From: Daniel O'Shea (Drew Smith) [REDACTED]
Sent: 17 January 2020 14:20
To: Simon Davis <Simon.Davis@arun.gov.uk>
Cc: Adrian Barker [REDACTED]
Subject: RE: Summer Lane, Pagham P/70/19/RES

Proposed Surface Water Strategy

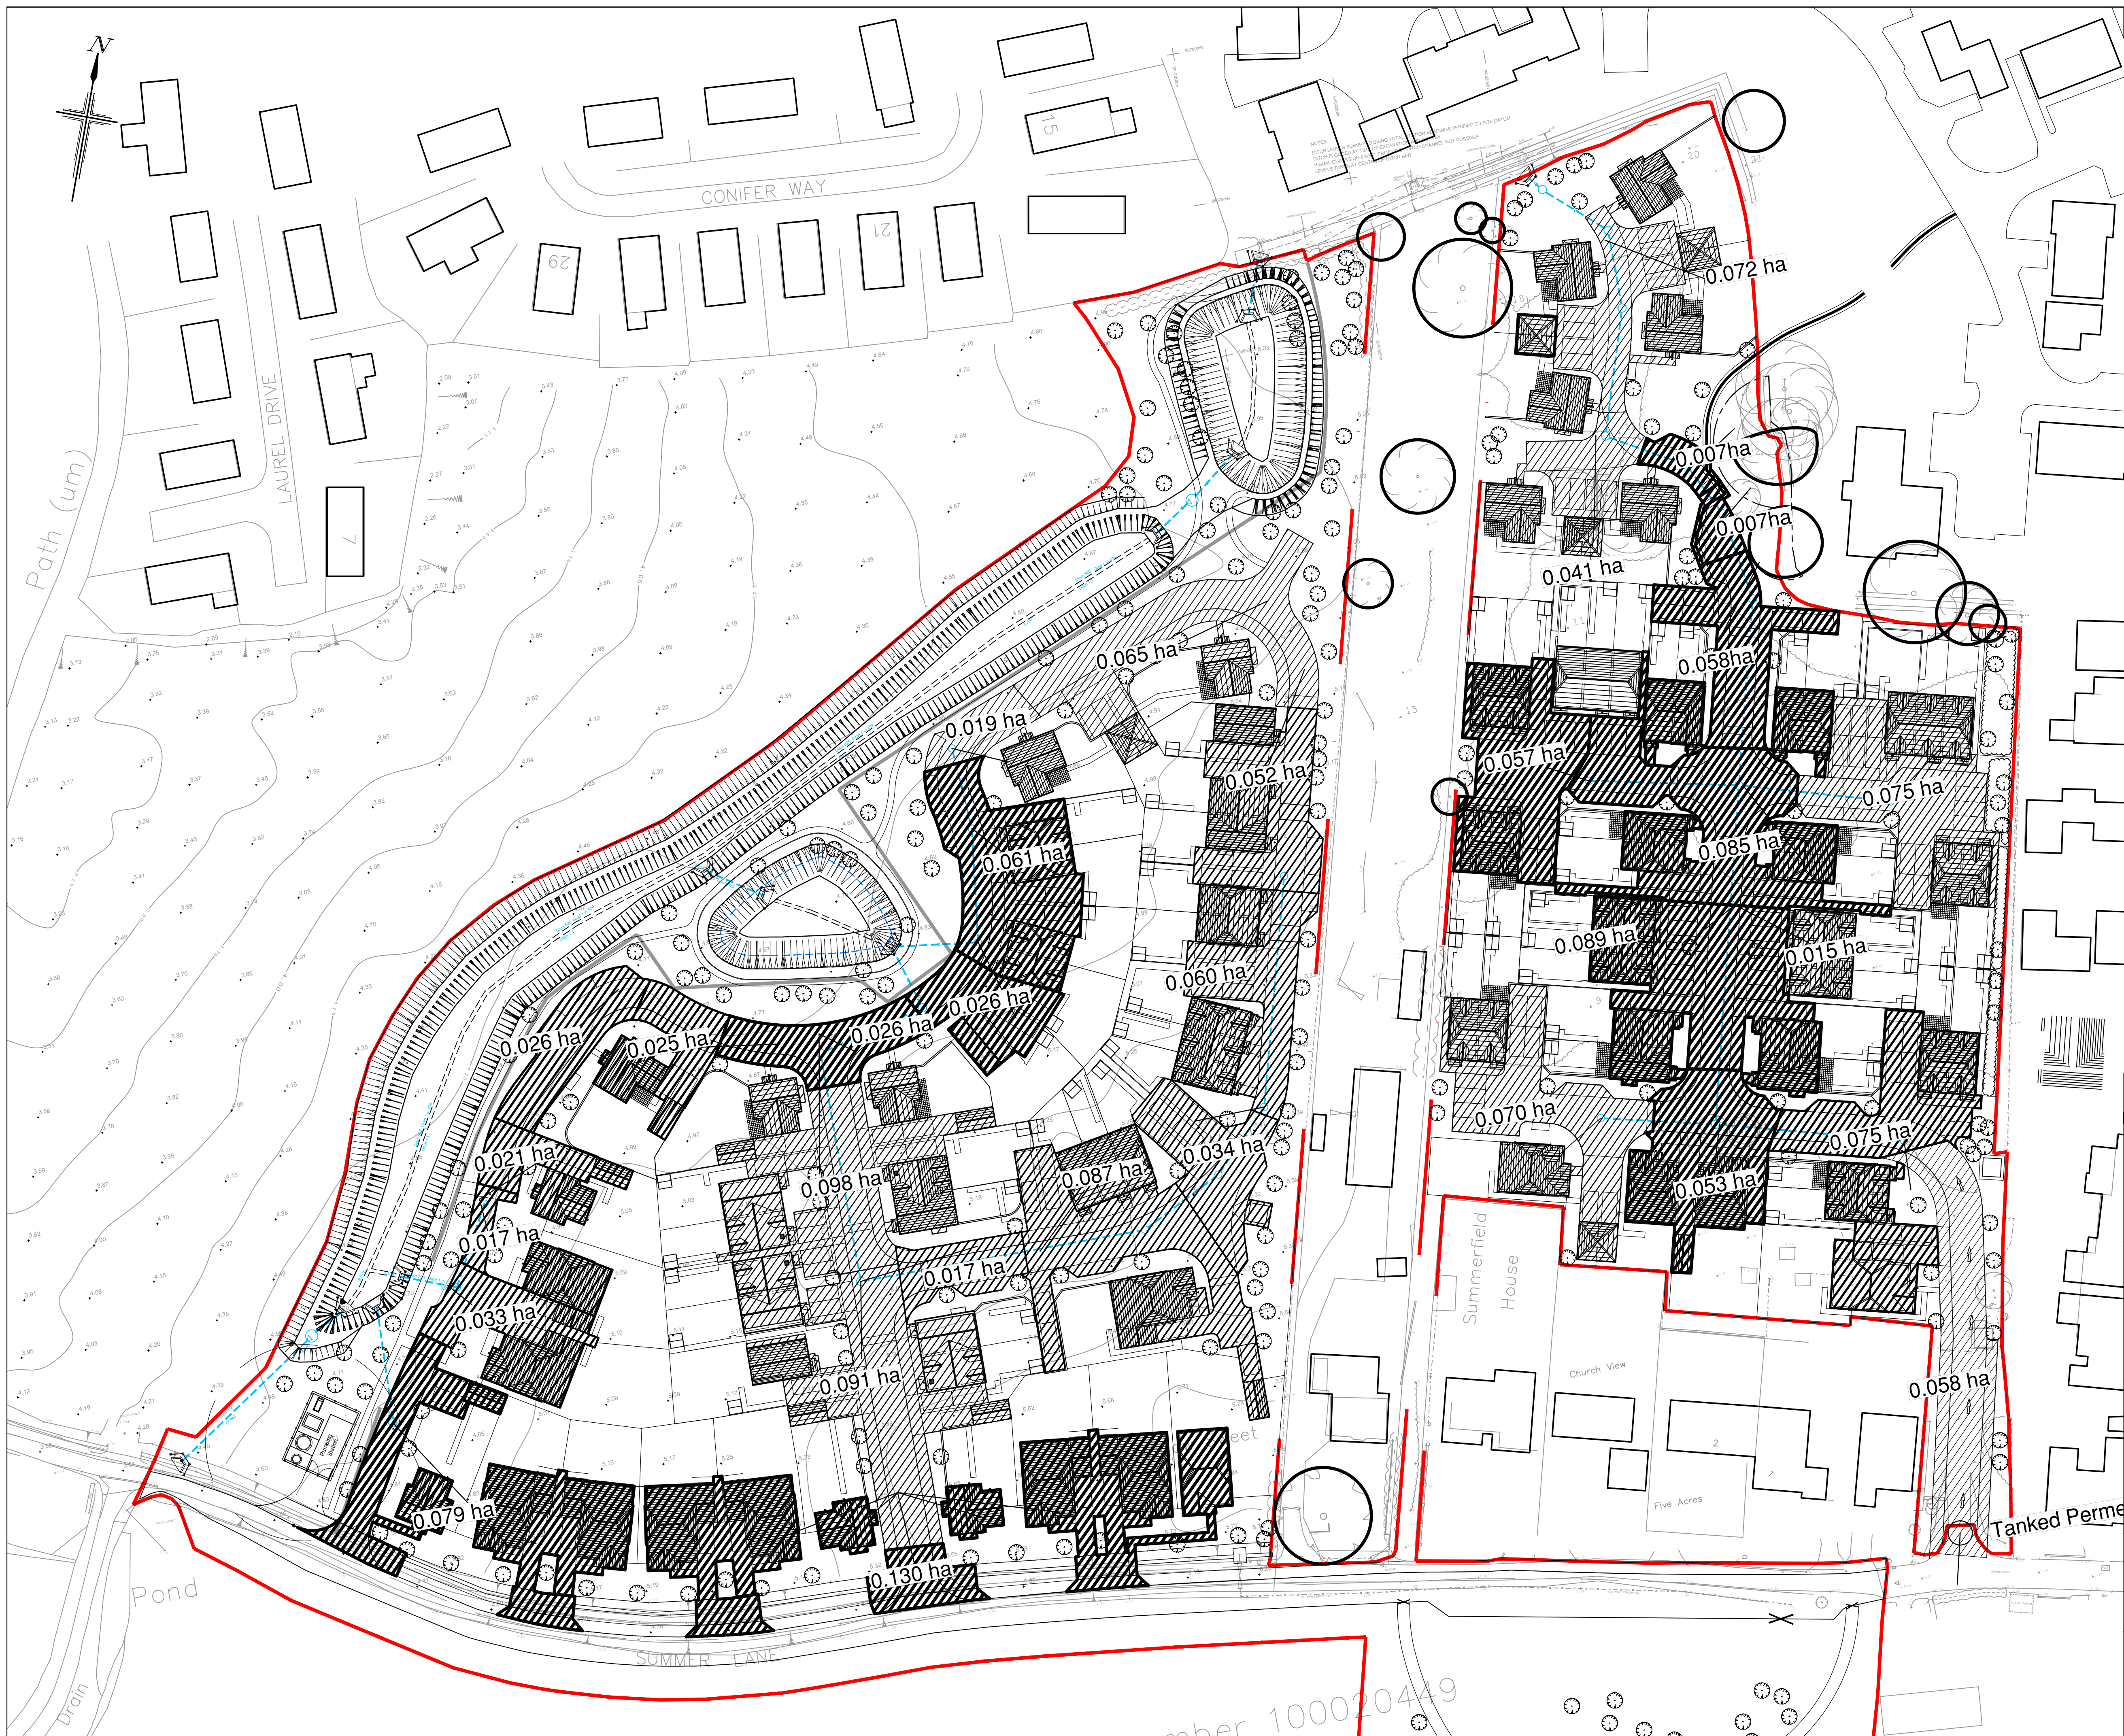
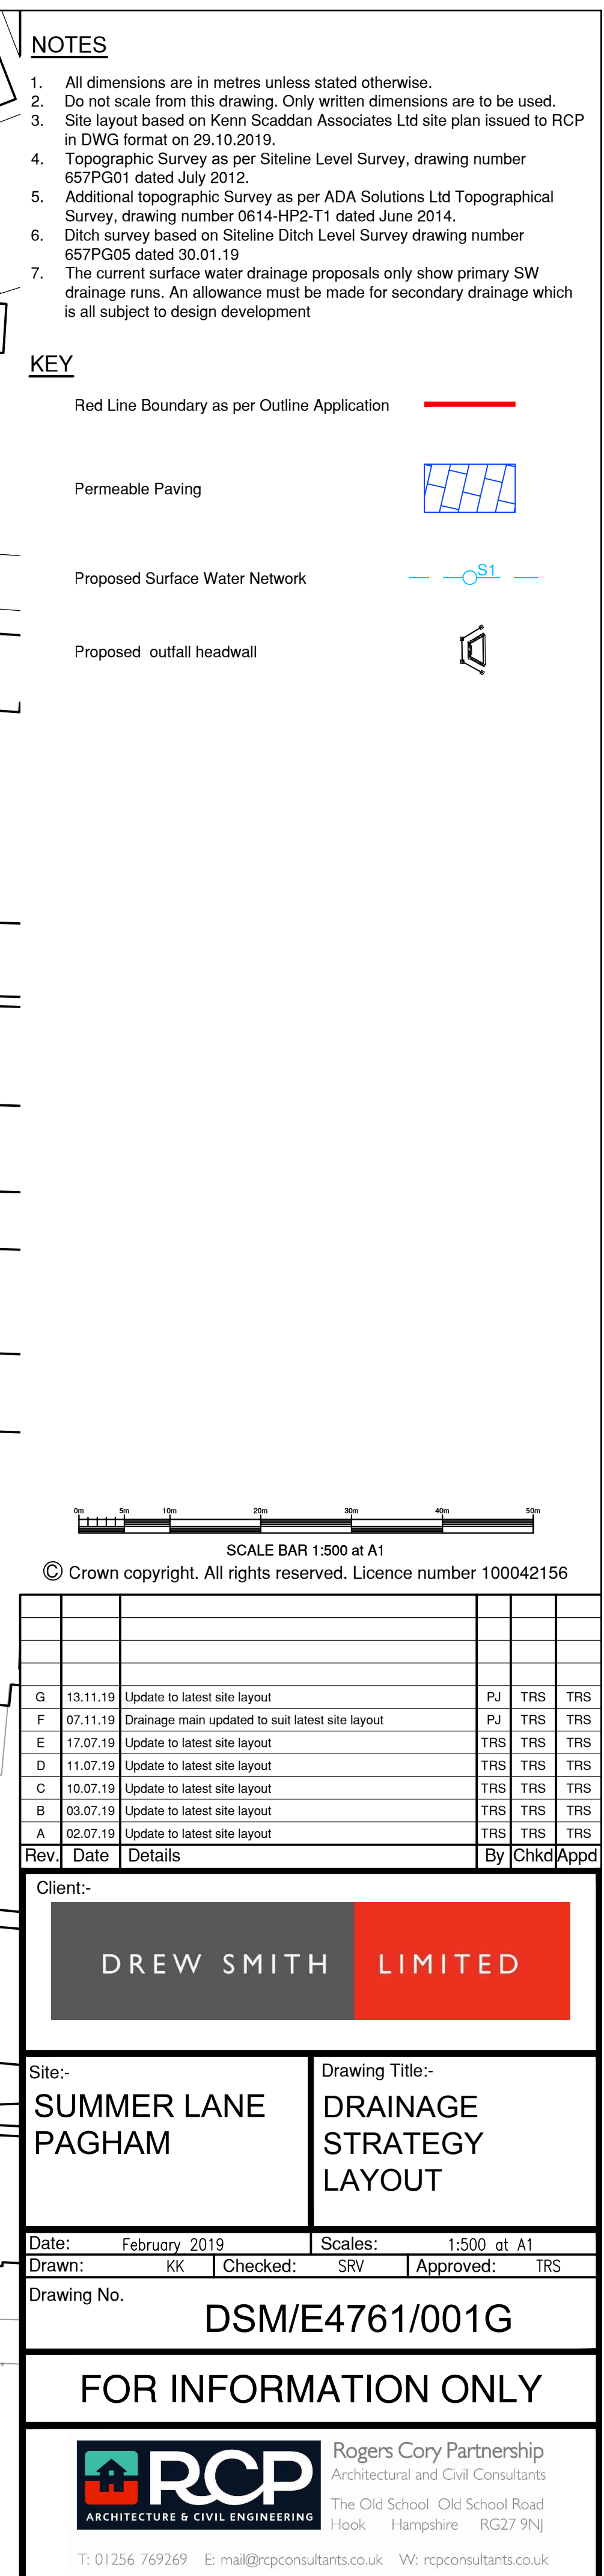
In terms of the proposal to redirect the northern ditch into the onsite suds system, and the fact that groundwater (which cannot be quantified) will enter the system via the northern ditch, is not a proposal that we would entertain, due to the unknown groundwater effects on capacity, operation of the suds, etc. A more satisfactory option would be to;

1. Keep the northern ditch independent of the onsite suds and work together to further investigate the existing culvert downstream (ie. on southern boundary of Mill Farm Park Estate) to ensure the free flow of water in a westerly direction.

2. Connect the surface water drainage from the eastern portion of the development into the western portion, rather than connecting the eastern portion directly into the northern ditch. Of course this will mean laying a pipe across third party land, but this can be achieved by either negotiation with the landowner or by approaching Southern Water to use their statutory powers to requisition a pipe across the land in question.

- *This is not considered to be a feasible option for the developer due to timescales involved.*
3. The 300mm pipe downstream of the developments discharge will need upsizing based upon the unknown groundwater influence in terms of capacity and to also reduce blockage risk.

- *As stated, Mill Farm Park Estate assets should be avoided. Ditch A (northern ditch) has sufficient capacity to take flow from Crayfern and eastern portion of Site.*

- *As the 300mm diameter pipe is on third party lands, it is down to the landowners and their duties as a riparian owners to maintain this 300mm diameter pipe. However, if the Council in their role as LLFA facilitates this work in terms of securing landowner approvals, the developer would be more than happy to upsize.*
